Immingham Green Energy Terminal

10.2 Notice of Consultation on Proposed Changes

Document Reference: TR030008/EXAM/10.2

NOTICE OF CONSULTATION ON PROPOSED CHANGES TO THE APPLICATION FOR DEVELOPMENT CONSENT

FIGURE TITLE
Site Boundary & Works Plans Changes between DCO Application (September 2023) & Change Application (March 2024)
Sheet 1 of 2

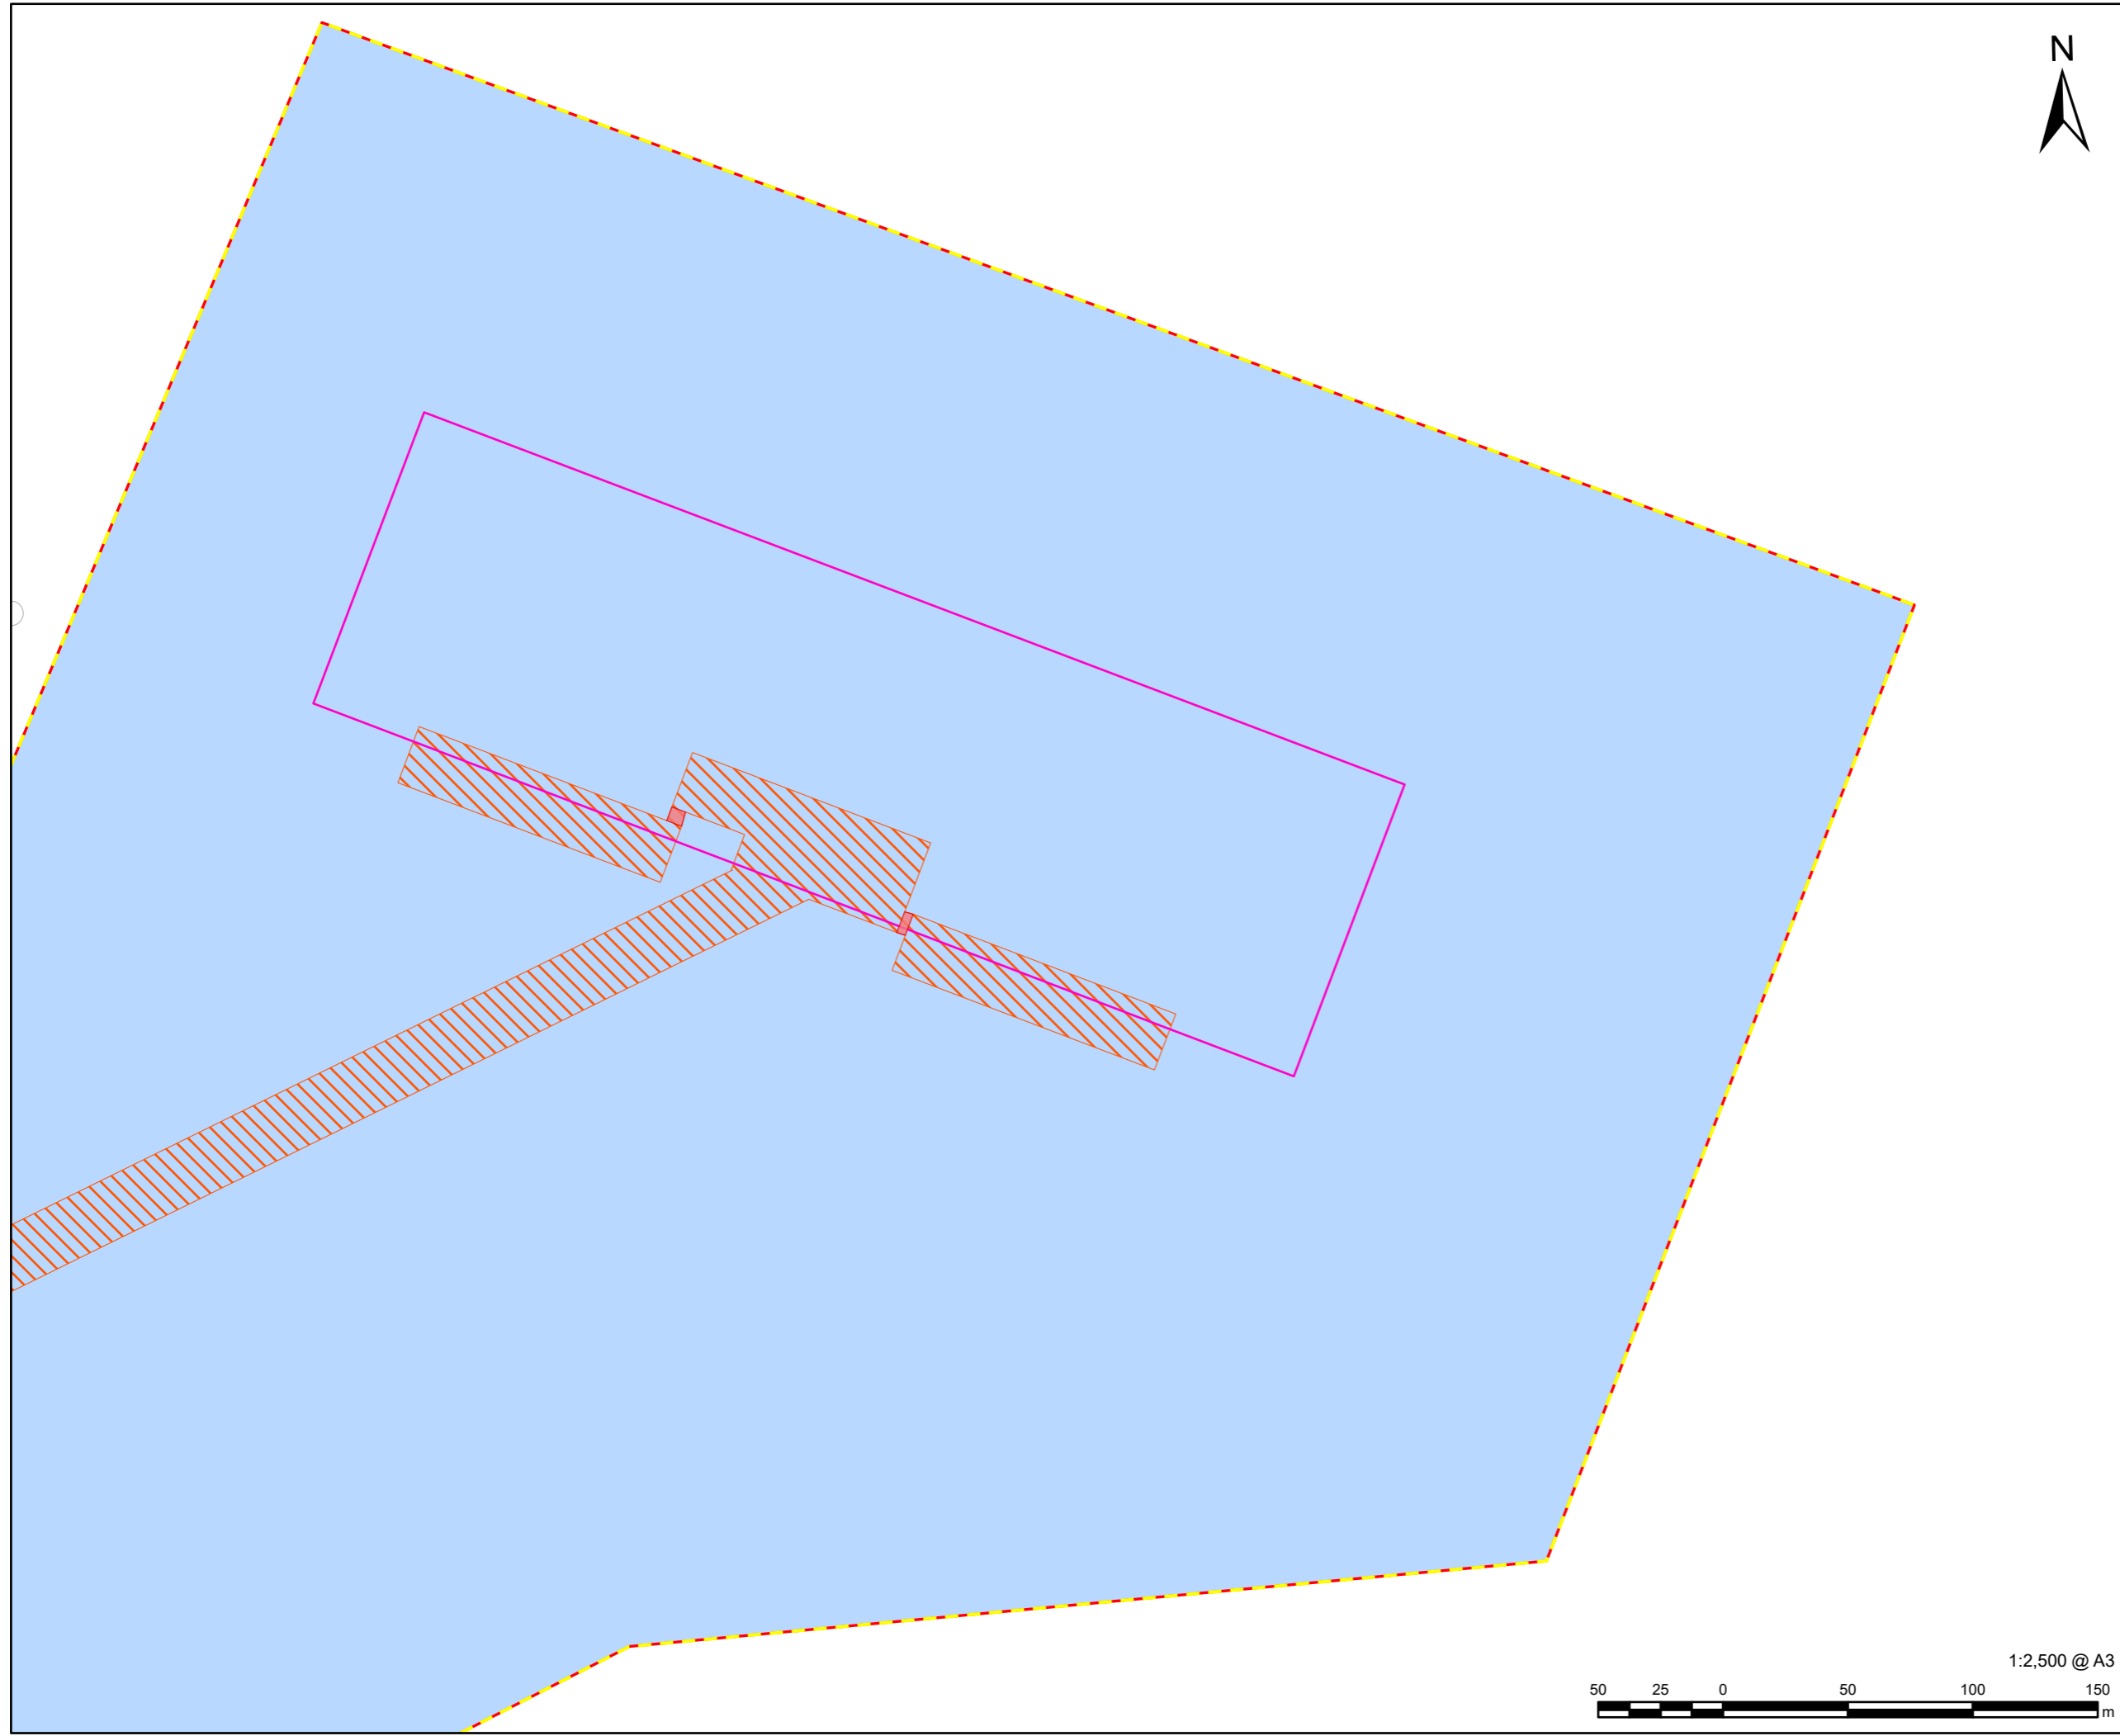
Change 1: change to the number of monopiles forming part of the IGET jetty berth (to be constructed as part of Work No. 1, referred to at paragraph 3, Schedule 3 of the draft Development Consent Order (“dDCO”) [TR030008/APP/2.1], from 2 monopiles in the original Application to 4 monopiles;

Change 2: change to the diameter of the piles supporting the approach jetty from 1.2m to 1.575m (also forming part of Work No.1 in the dDCO) to support the loading from the pipe racks, and flowing from the increased pile diameter, the distance required between the piles increases, and consequently the width of the approach jetty has slightly increased from 14m to 16m;

Change 4: addition of detail to Work No. 1a in the Works Plans [AS-002] to show the walkways linking the jetty head to the mooring dolphins. These walkways are already described at paragraph 1(a)(ii), Schedule 1 and at Paragraph 3(2)(a)(ii) of Schedule 3 of the dDCO.

FIGURE TITLE
Site Boundary & Works Plans Changes between DCO Application (September 2023) & Change Application (March 2024)
Sheet 2 of 2

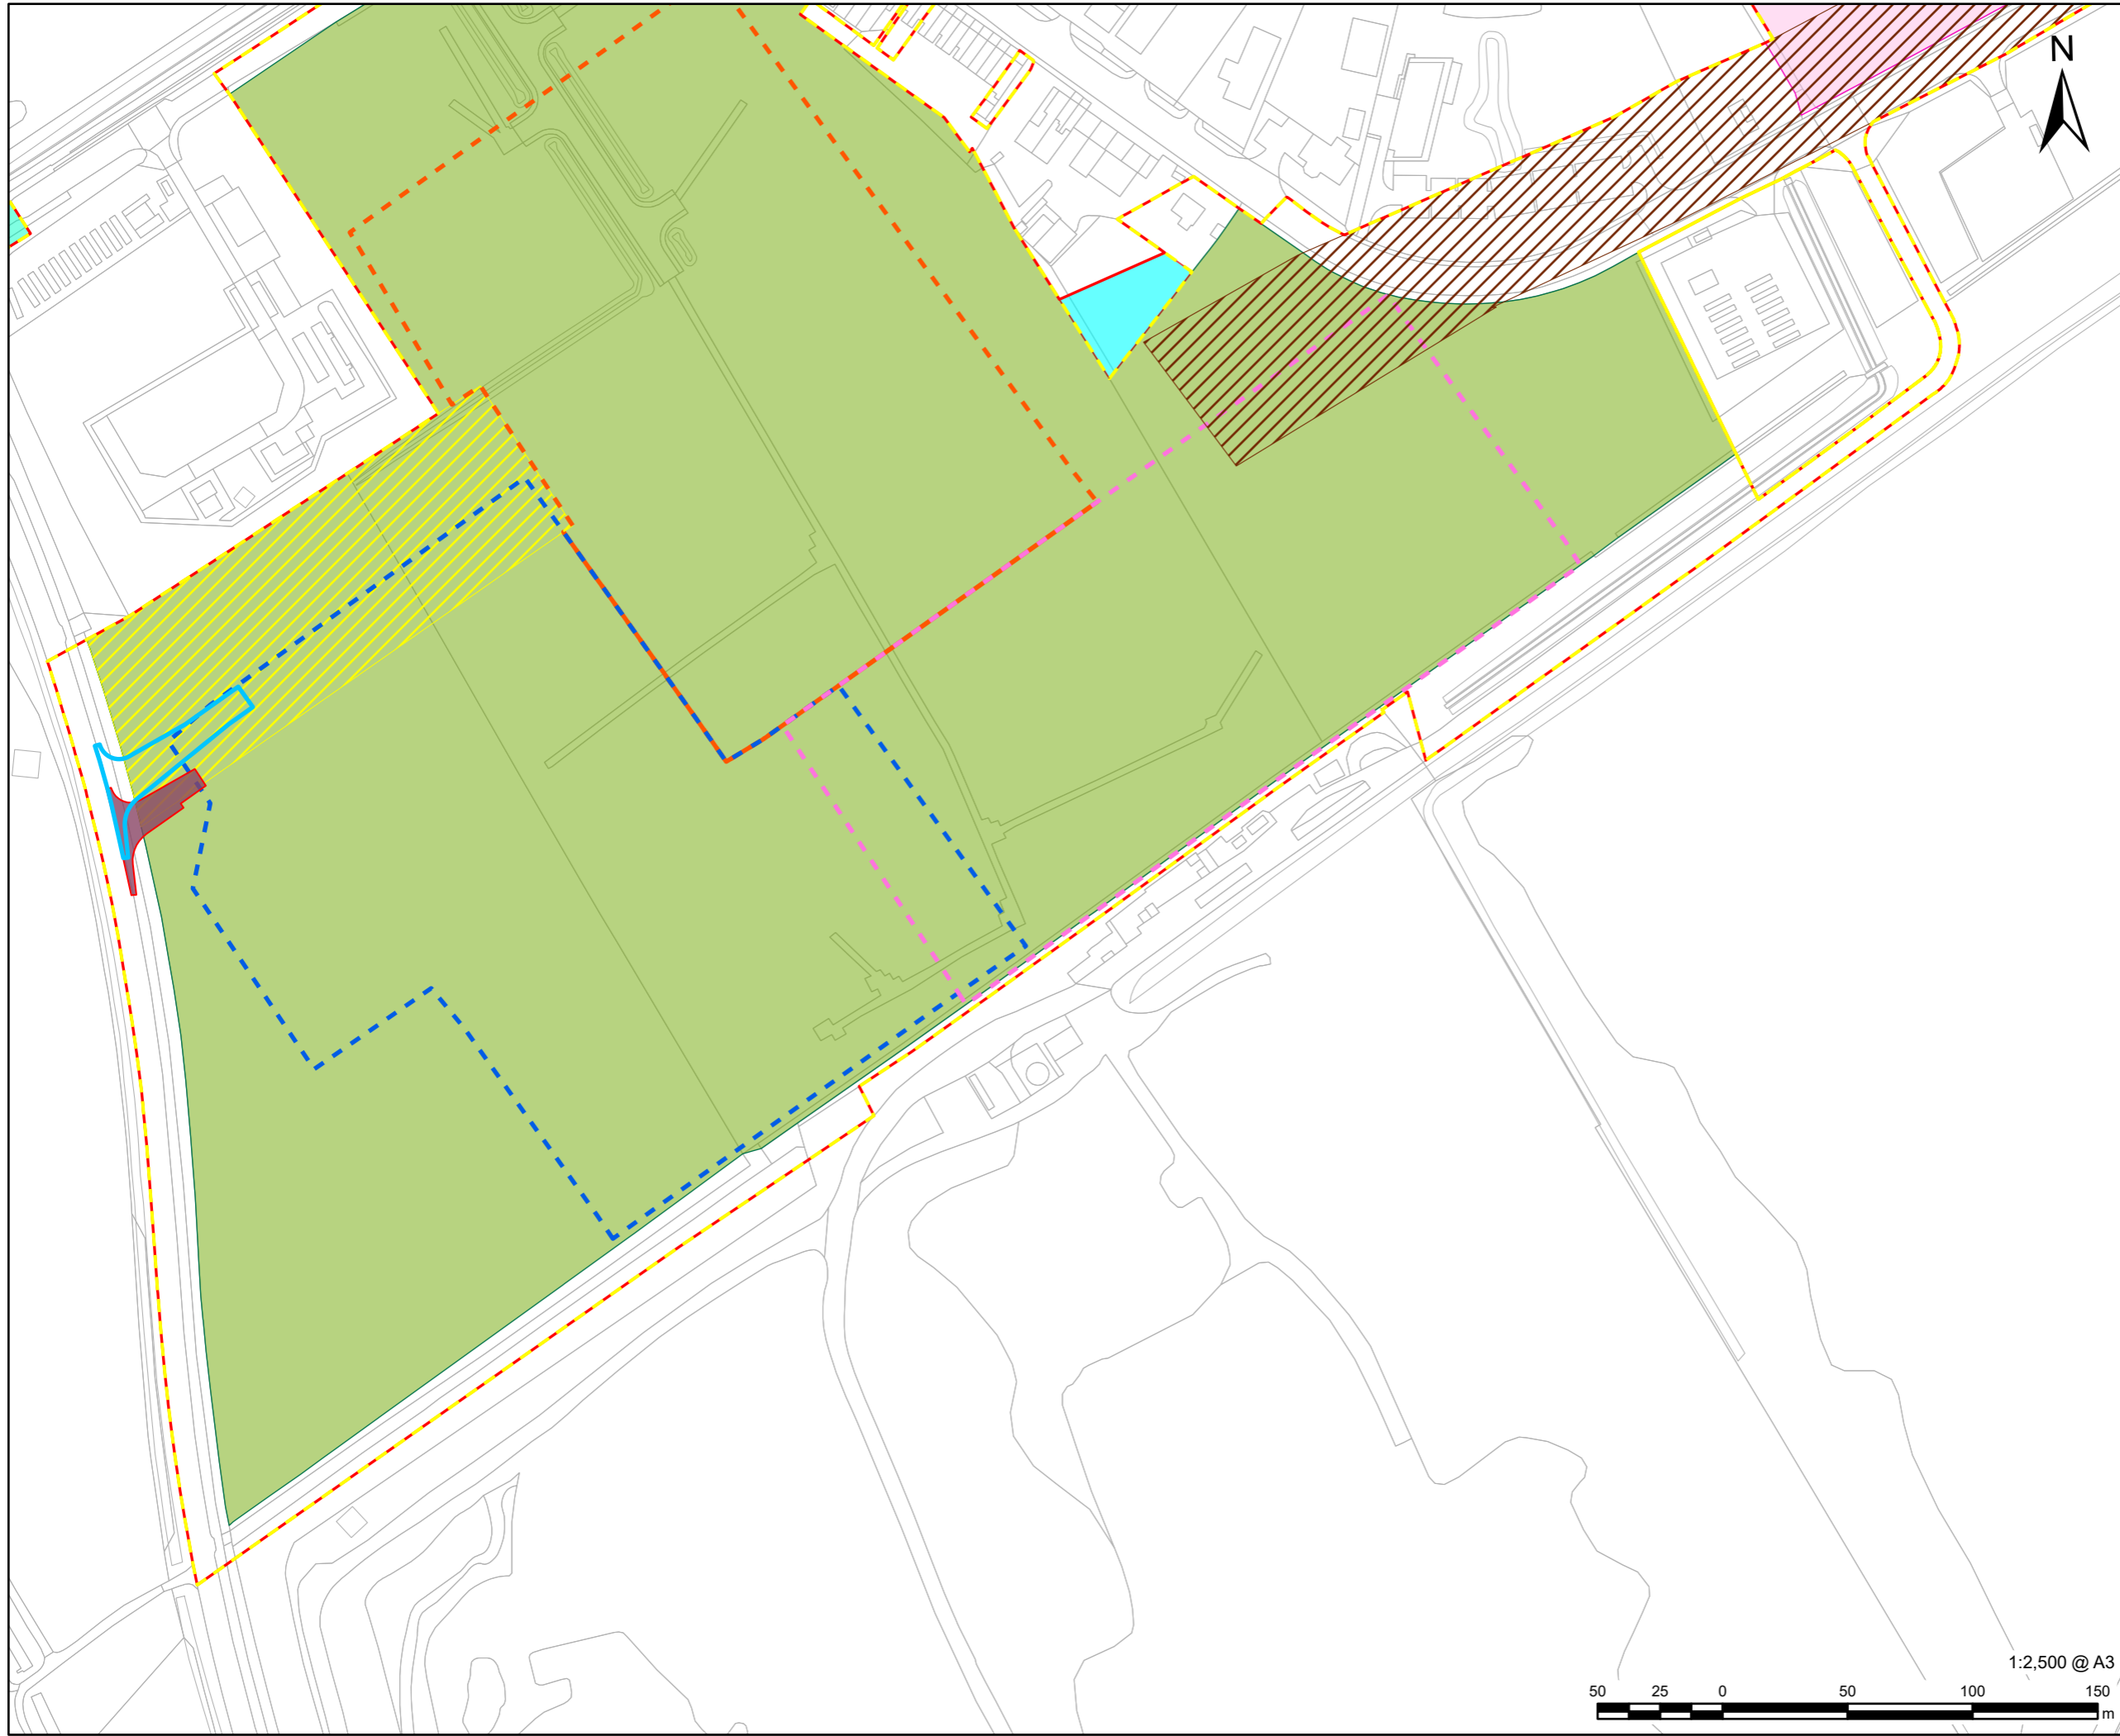
Change 3: Amendment of site boundary at the eastern edge of Work No. 7 to include additional land for temporary construction purposes and minor changes to the western accesses from the A1173 to Work No. 7;
